TOWN AND COUNTRY PLANNING ACT 1990

FULL

Reference: H16-1092-25 **Date of Decision:** 6th January 2026
Applicant: M Antonica & T Costianu
57 Aintree Drive
Spalding
Lincolnshire
PE11 3BT
Location: 57 Aintree Drive Spalding Lincolnshire
Description: Erection of two storey side extension with attached garage, garage conversion, internal alterations & erection of boundary wall & gate

Drawing name:
Front Elevation: As Existing + As Proposed

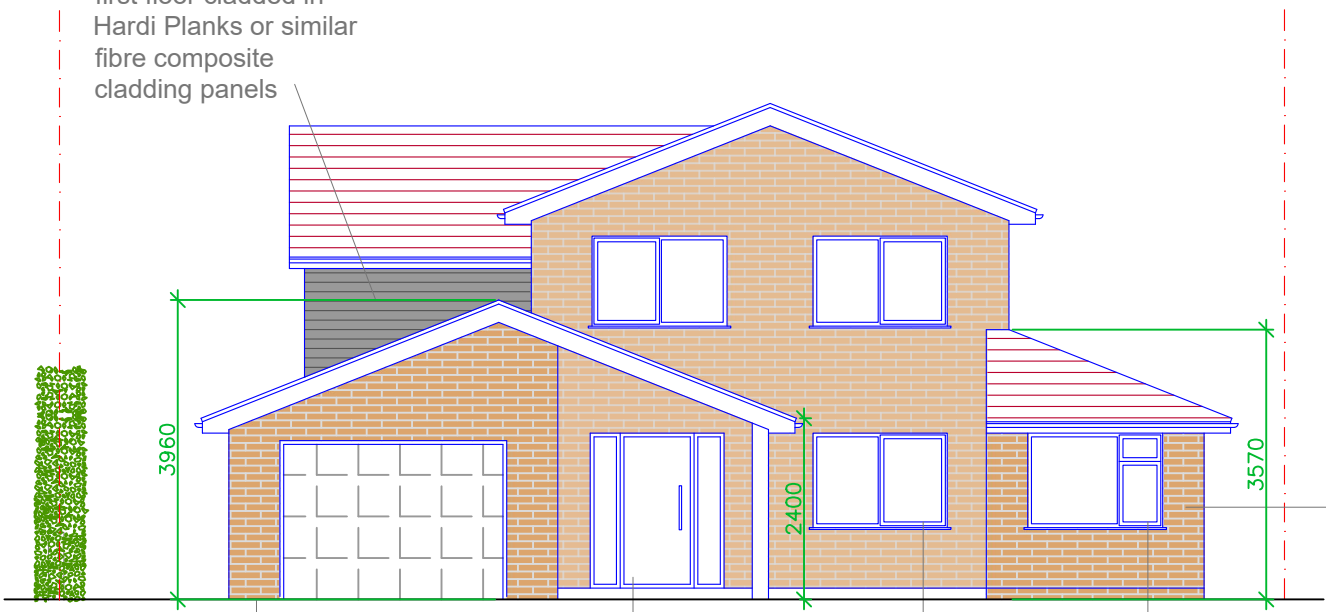
- 1 The proposed extensions would introduce atypical features, such as the use of cladding on the first floor, whilst also resulting in a dwelling which appears overly large in comparison to its immediate counterparts and the plot it sits within. The proposal would result in an incongruously large dwelling, which fails to reflect the existing character and uniformity of the area and the surrounding built environment. The prominence of the corner plot location would increase the visibility of the works, thereby exacerbating the harm caused and the perceived scale of the works. Likewise, the use of cladding fails to reflect the existing consistency of materials along Aintree Drive, resulting in an alien feature at odds with the area.
